## Appeal Decision

**Appeal Ref: APP/R5510/W/24/3336921**

**The Great Western, Dawley Road, HAYES, UB3 1NF**

Project no.	Sequential	Bldg/Floor	Detail	Rev
KAD	04	A	EX	.

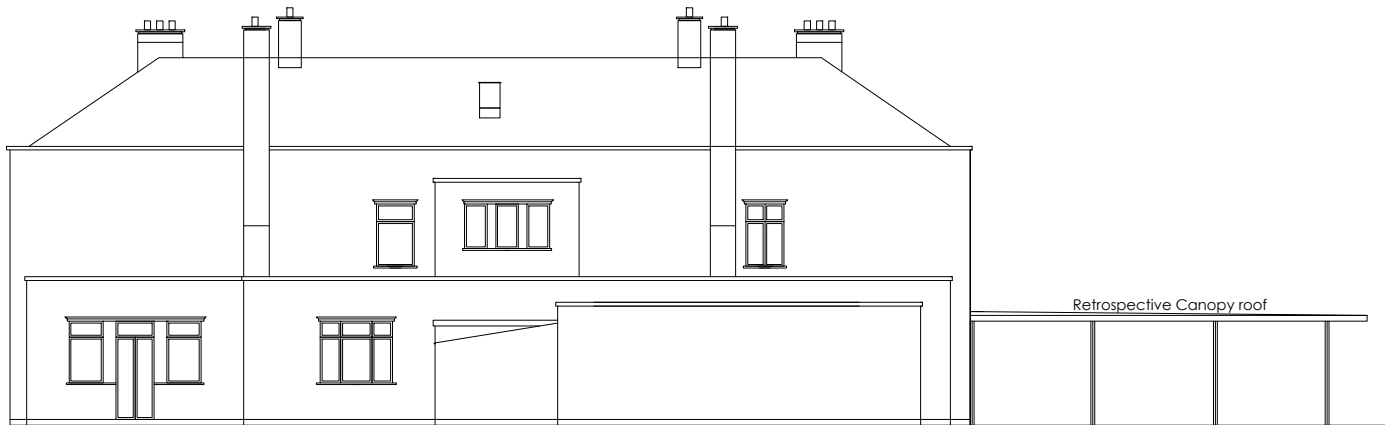
2. I saw on my visit that the roofed structure has already been constructed. It is positioned broadly as shown on the Proposed Elevations, Reference 04 A EX. However, the Proposed Plans, Reference 05 A PP, show it in a slightly different position, closer to the front boundary fence adjacent to the car park serving the appeal property. Nonetheless, in this case, the discrepancy in the positioning is not significant and the precise positioning of the roofed structure has not affected my decision on the main issue.
3. On 12 December 2024, a revised National Planning Policy Framework (the Framework) was published. Those parts most relevant to this appeal have not been significantly amended. I will refer to the updated paragraph numbers where necessary in this decision.
